Fire Marshal Division

**Re: Marley & Co. – Salon
15 W. Front Street
Lillington, NC 27546**

Application Number FMFW1810-0011

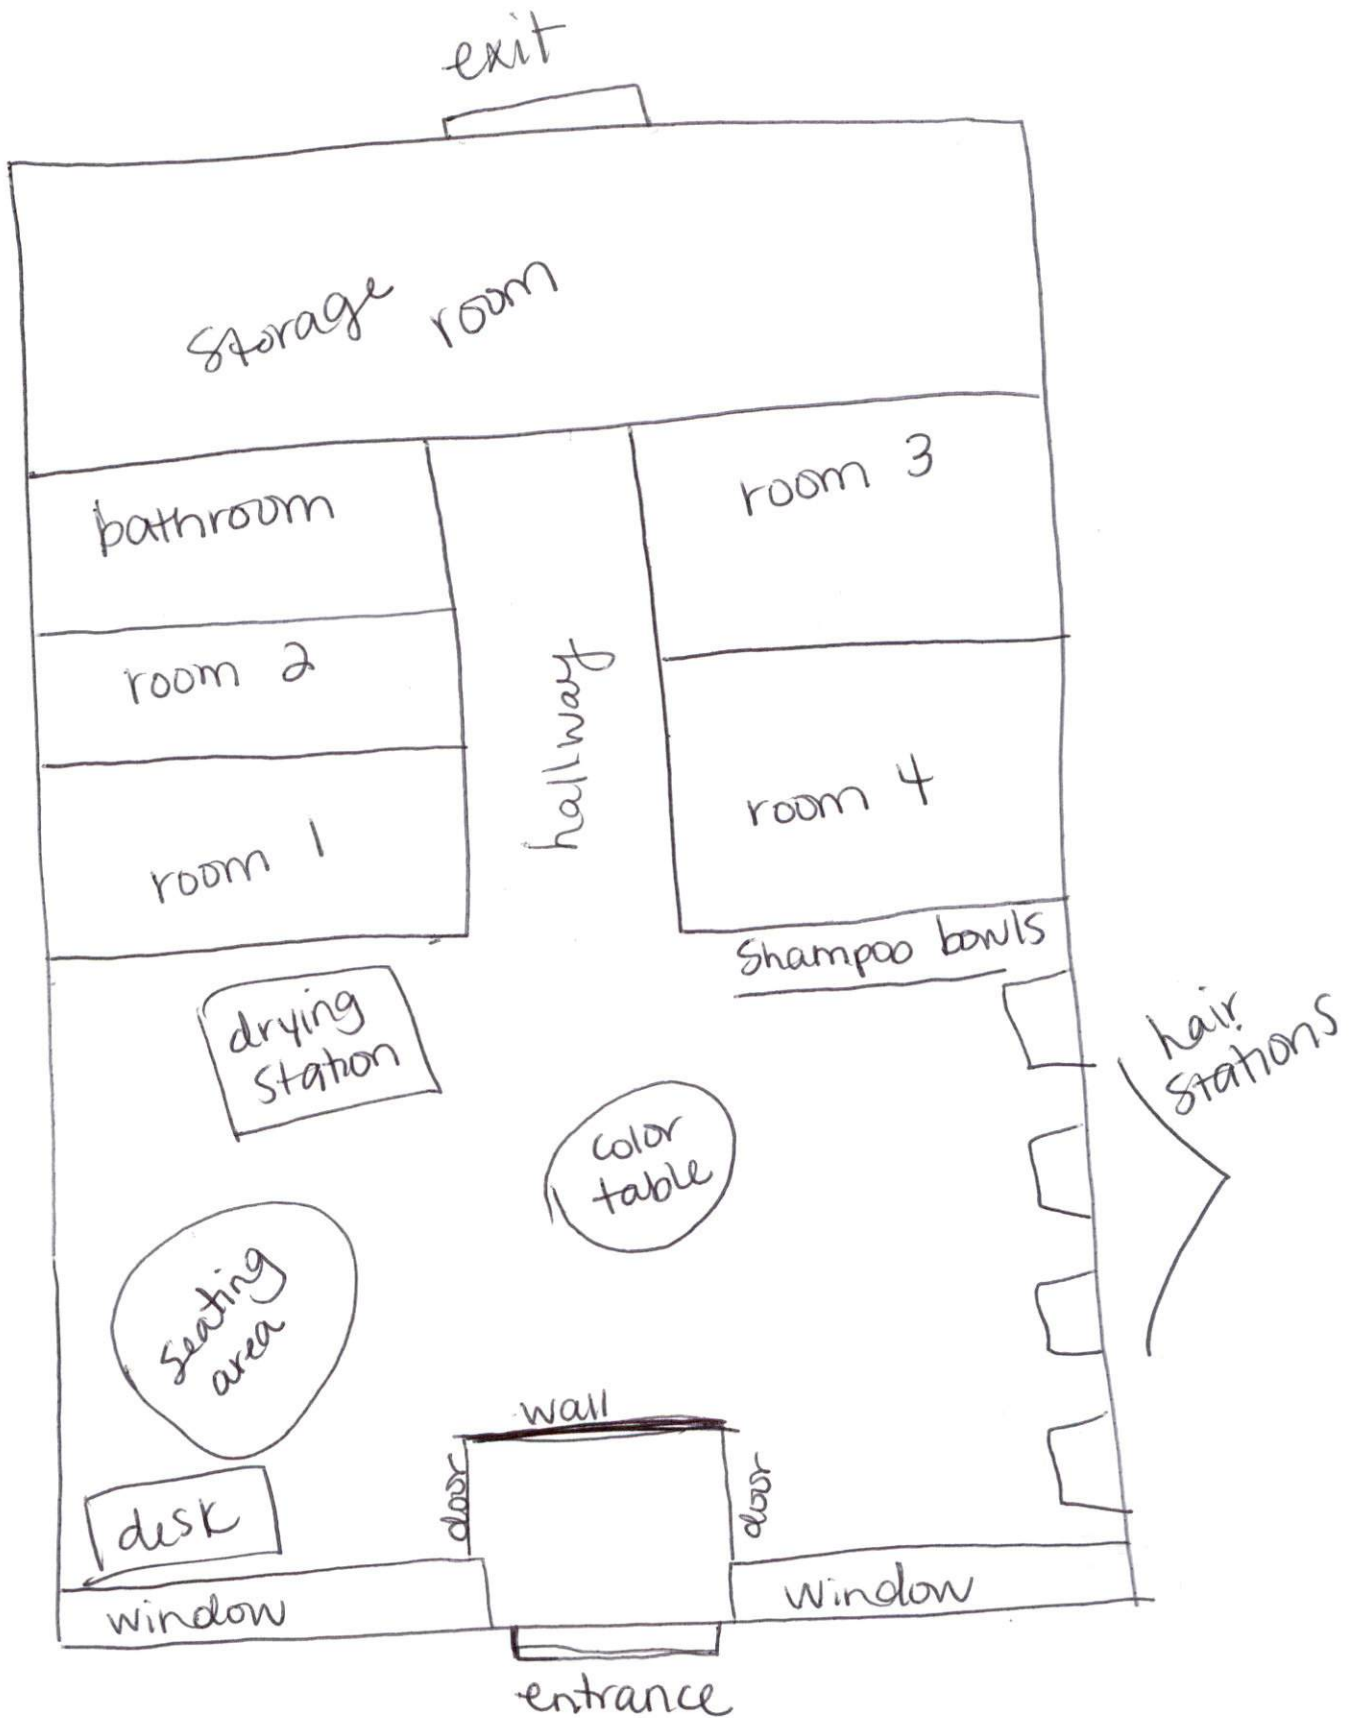
- **906.1 Fire Extinguishers**
 - Minimum of (1) 2A10:BC fire extinguisher shall be installed per 75' distance of travel.
 - All Fire extinguisher shall be properly mounted and tagged by a fire extinguisher company.

- **506.1 Knox Box**
 - The building owner has been required to install a Knox box.
 - Provide entry key to be placed in the complex Knox box.
